CITY OF PORTLAND, MAINE
DEVELOPMENT REVIEW APPLICATION
PLANNING DEPARTMENT PROCESSING FORM

Project Name/Description

RE: 545 Auburn Street (lot #2) - 382A-D-022 - R-2 Zone - application #05-0219

GRADING PLAN LOT 2  
OF:  
**AUBURN ESTATES**  
AUBURN STREET/LONGVIEW DRIVE  
PORTLAND, MAINE  
FOR:  
**SHARON PELLETTIER**  
P.O. BOX 9739-1105  
PORTLAND, MAINE 04104-0539

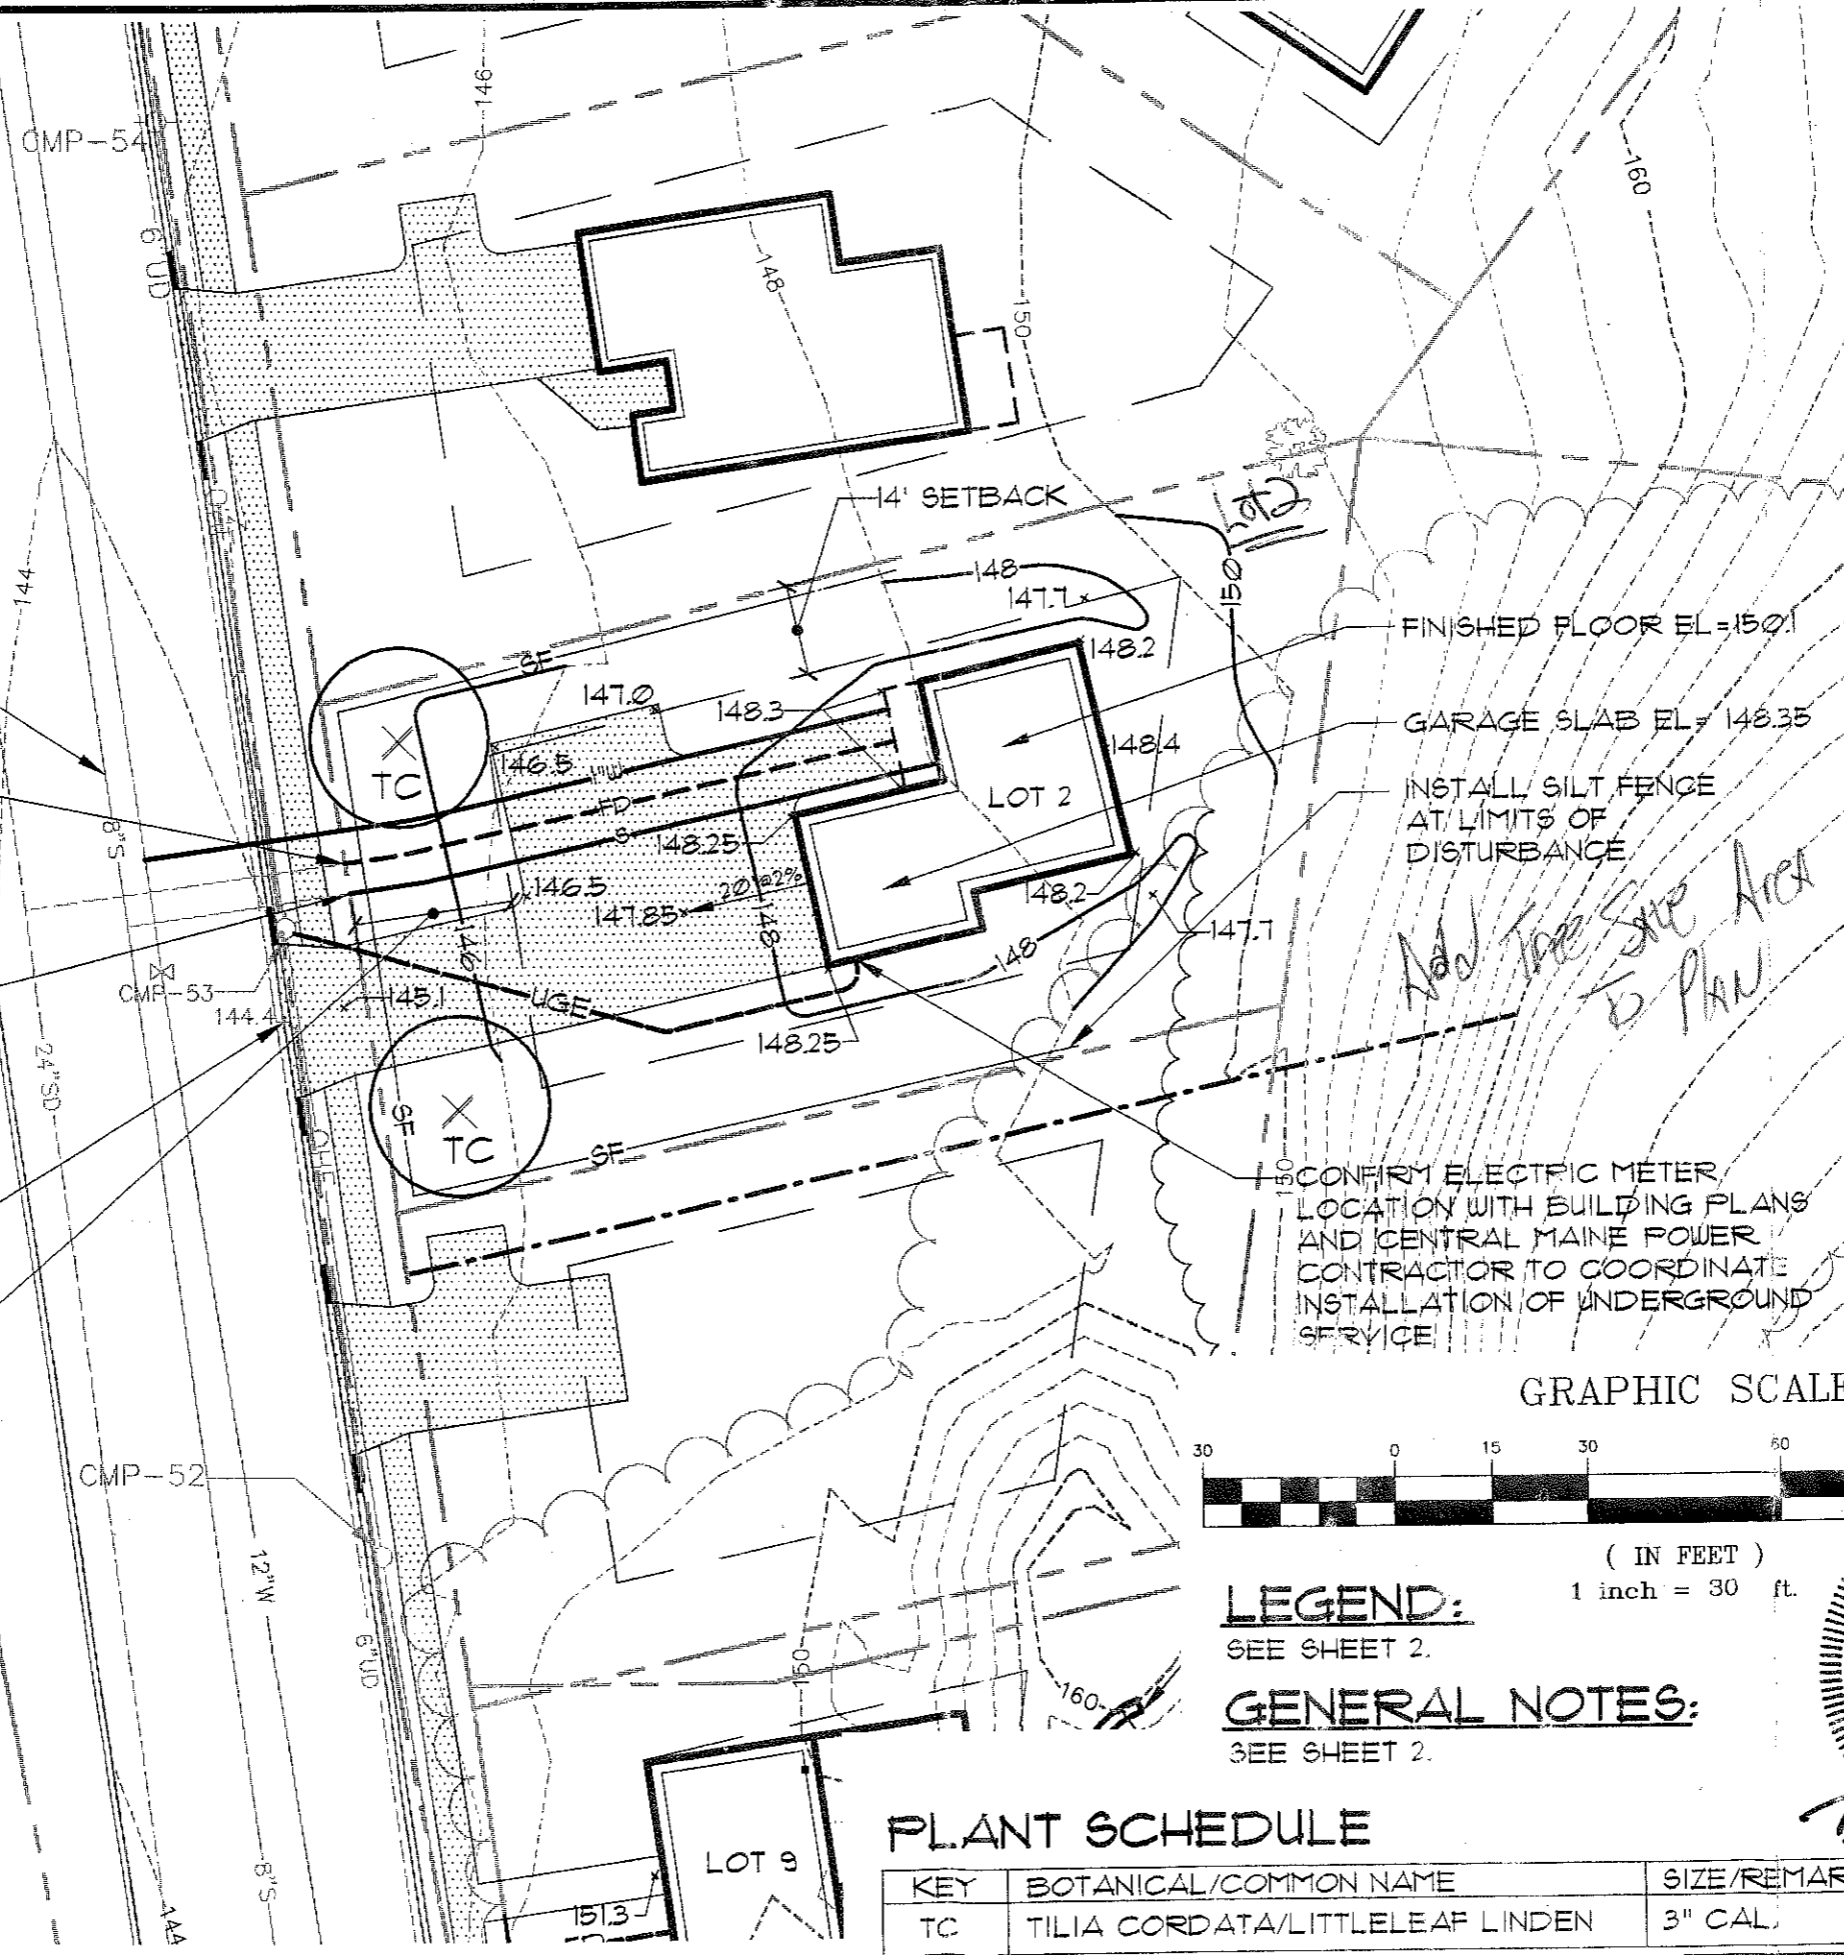
Add Tree-Save Info from
LANDSCAPE PLAN (SUB PLANS)
TO SITE PLAN.
